## Site plans - building permit

Wed, May 13, 2020 at 5:33 PM

Here are the comments on the plans from DPW and our office:

PAVEMENT MARKING DETAILS

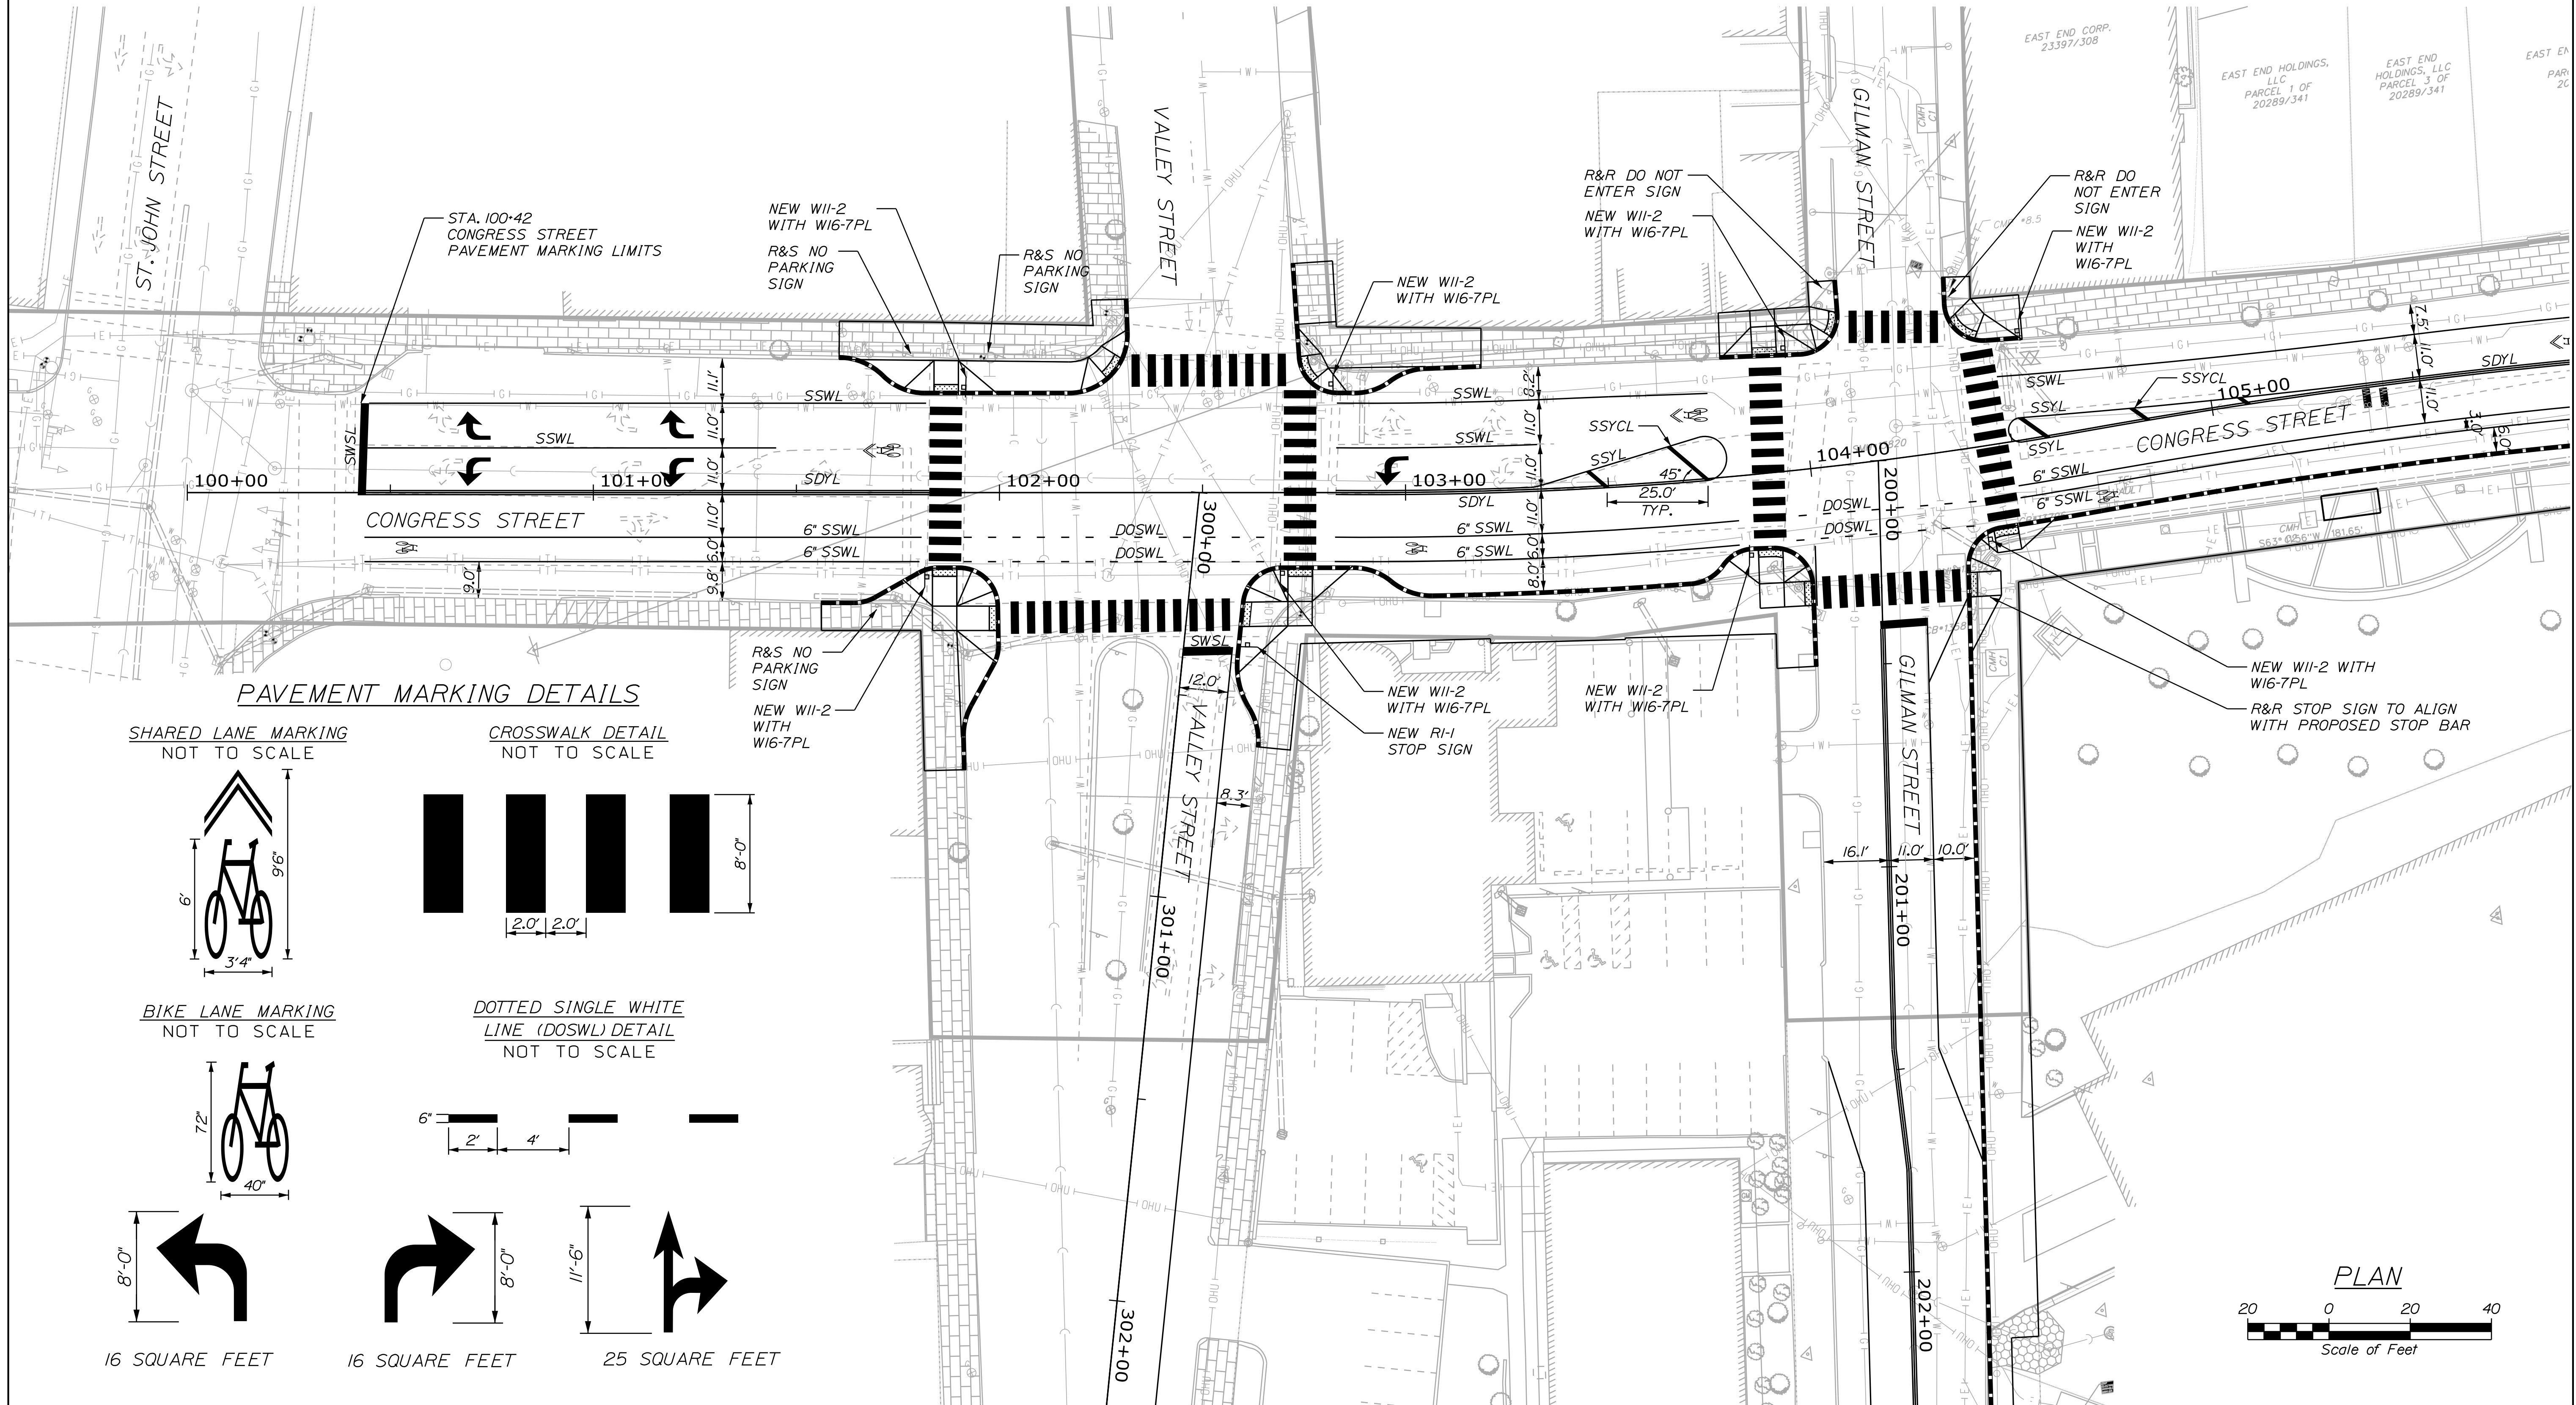
- The symbol for bicycle lanes should show the City and MUTCD standard helmeted cyclist.
- The plans do not indicate a phased approach to the street improvements. At a minimum, the improvements shown on the west side of the Congress/Valley intersection should be completed PRIOR to removal of the signal here. Please document on the plans and in the CMP.
